I refer to Determination of Major Project 06-0232 in respect to the Southern Highlands Regional Shooting Complex, Wattle Ridge Road, Hill Top.

Condition of Approval C1 provides for a staged vegetation clearing, and notes in particular that clearing for the 500m range is to be in accordance with Drawing No. 21-17859-C004 Rev A prepared by GHD. In summary, the approval permitted certain vegetation clearing of the head of the proposed 200m rifle/pistol range to allow access to the sedimentation pond area to the west of the 500/200 ranges.

Accordingly, we seek approval by the Department of Planning of the re-located site for the 500m rifle range, 200m rifle/pistol range and sedimentation pond location at the Southern Highlands Regional Shooting Complex as per the attached drawing.

Client: COMMUNITIES NSW
 Project: HILL TOP RANGE
 Drawing: CLEARING SETOUT PLAN
 Sheet: SHEET 1
 Title: A1
 Drawing No: 21-17850-C004
 Rev: 0

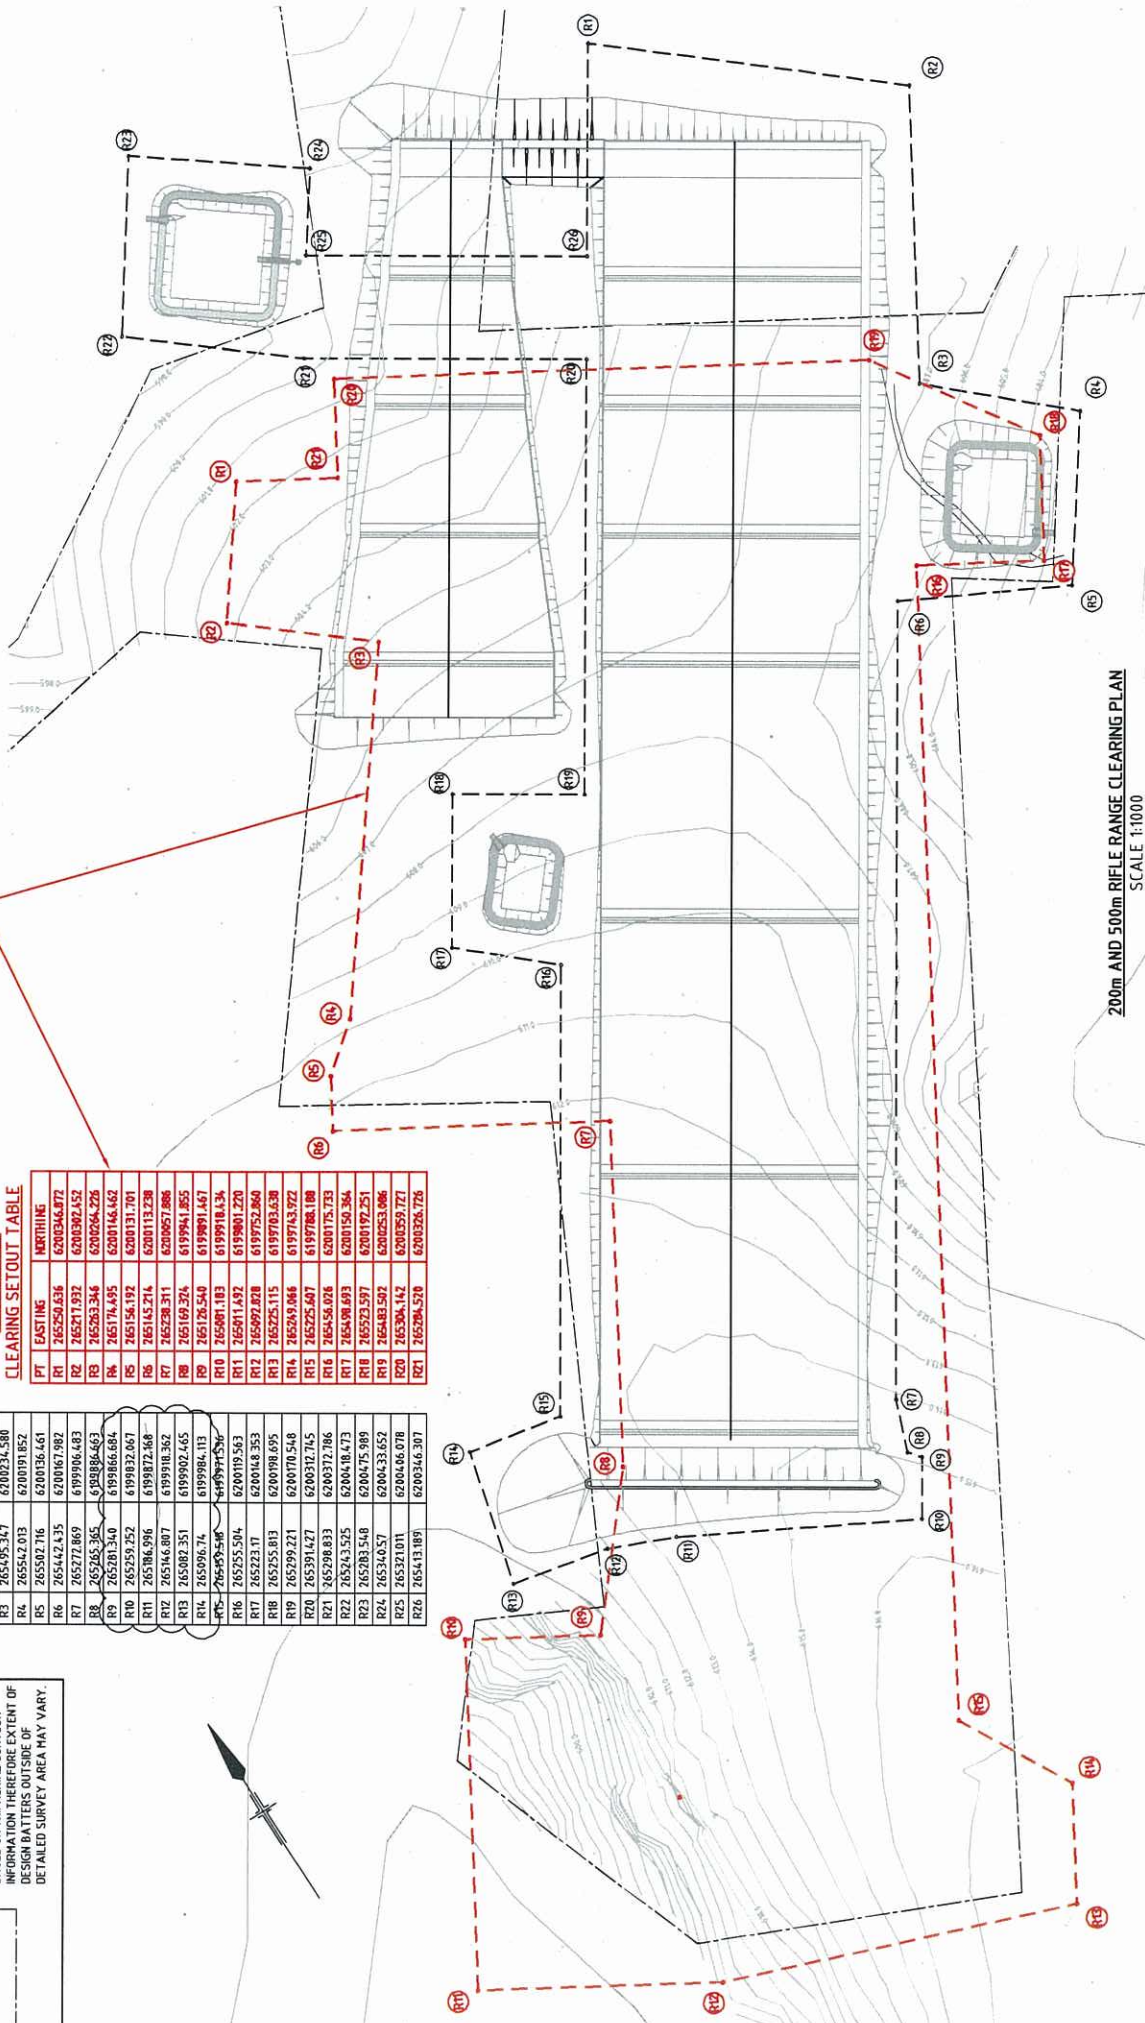
Advice indicates that the C1 approval did not incorporate the exact drawing reference provided by GHD to allow this clearing to take place. We would seek for this matter to be rectified in order that the Approval details the correct drawing.

It was finally agreed with GHD that the best approach to reduce the significant earth moving exercise, including the excessive cost involved, would be to lower the range and to re-locate it approximately 50m towards Wattle Ridge Road. The effect of this relocation would allow a fully functioning range without the need to clear additional vegetation and would overcome the requirement for a massive earth clearing operation.

Detail on the re-located 500m rifle range is included in the attached drawing, Drawing No. 21-17850-C004 prepared by GHD. We apologise for not submitting this re-located position for the 500m range.
